Question Reference	Question	South Norfolk District Council Response
GEN1.3	<p>National and local planning policy compliance tracker</p> <p>Since the policy compliance document submitted with the application [APP-086] was produced (1 April 2025) a number of local and national planning policies have been updated or newly issued. This includes the energy suite of National Policy Statements (NPS) EN-1, EN-3 and EN-5 (Updated National Policy Statements). The transition provisions set out in section 1.6 of NPS EN-1 (December 2025) apply to the application as it was accepted prior to publication of the revised policy. The updated NPS are capable of being important and relevant considerations in the decision-making process.</p> <p>The applicant submitted a policy compliance tracker [REP1-133] at deadline 1. It includes an assessment of the updated NPS alongside those which are designated, and a number of new insertions including the consultation draft National Planning Policy Framework (NPPF), local plan policies and neighbourhood plan policies.</p> <p>The listed relevant planning authorities and Parish Councils (PC) who have a newly adopted or emerging local plan and neighbourhood plan ar

Doc Ref: 7.12

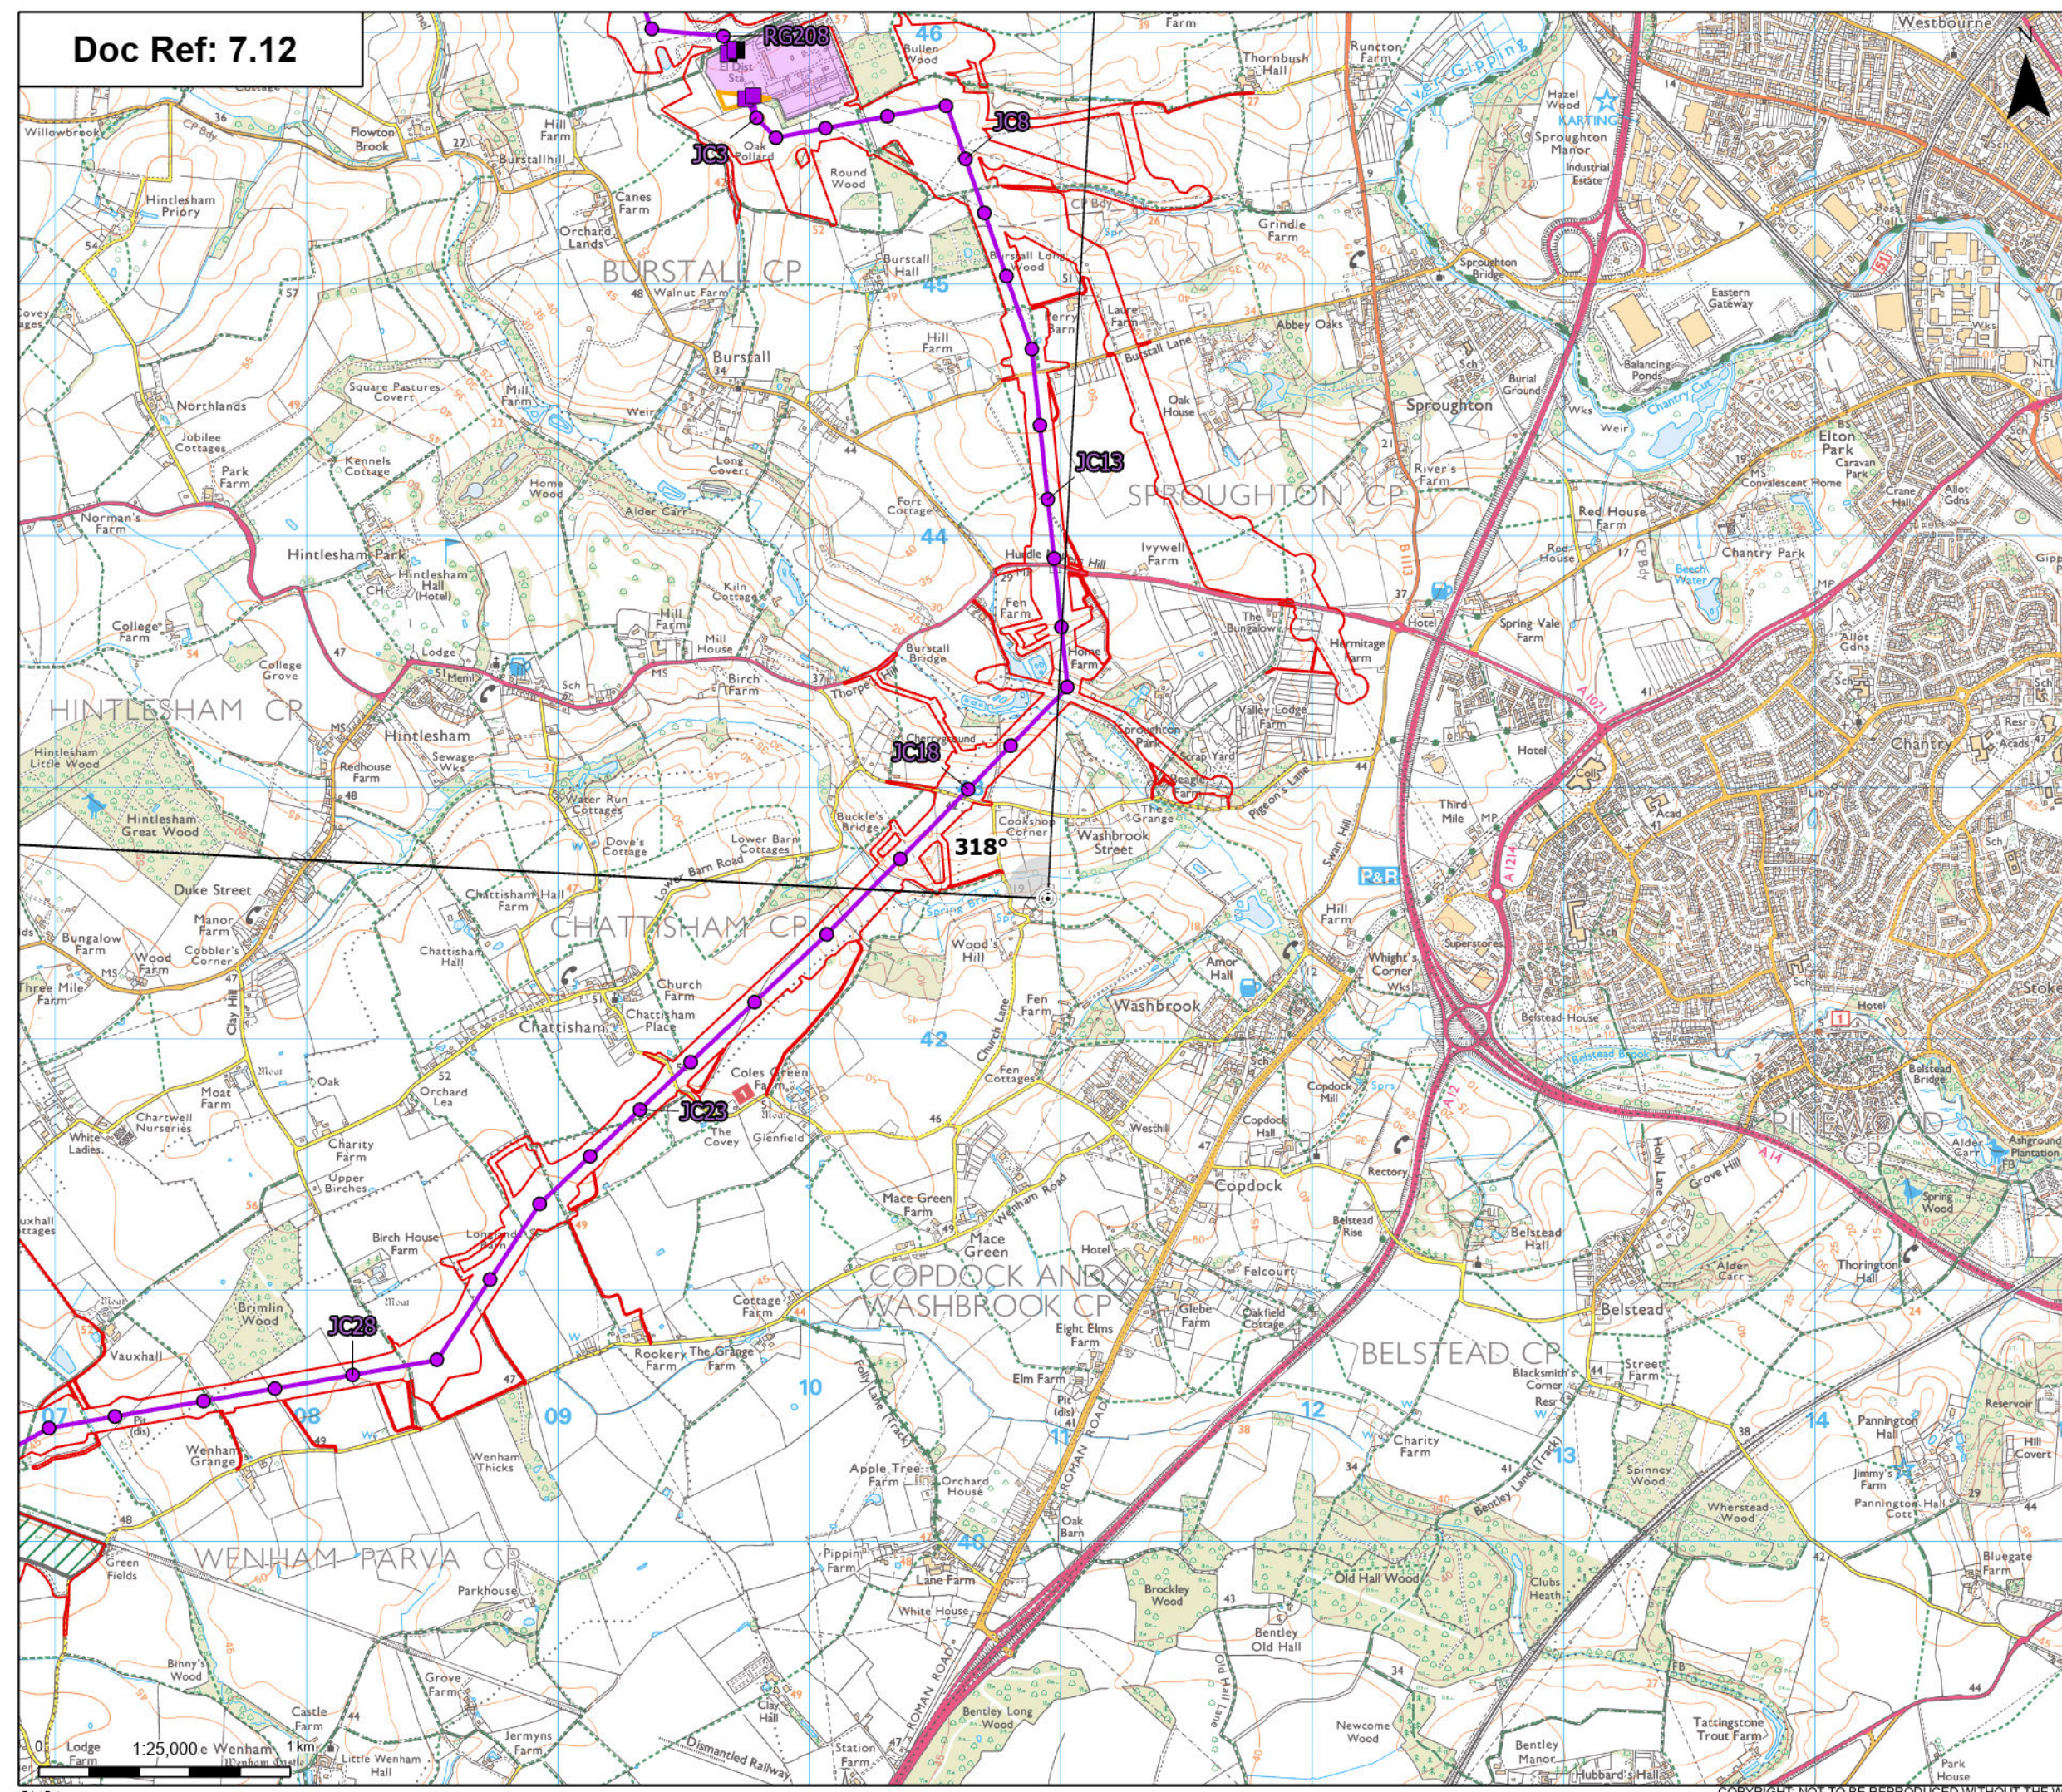
HE1.12	<p>Heritage Visualisations – 1 A range of heritage visualisations are provided [APP-350] and [APP-351].</p>	<p>SNDC remains concerned that the viewpoints provided for St Remigius do not adequately represent the church's setting or the visual impact of the proposed pylons.</p>
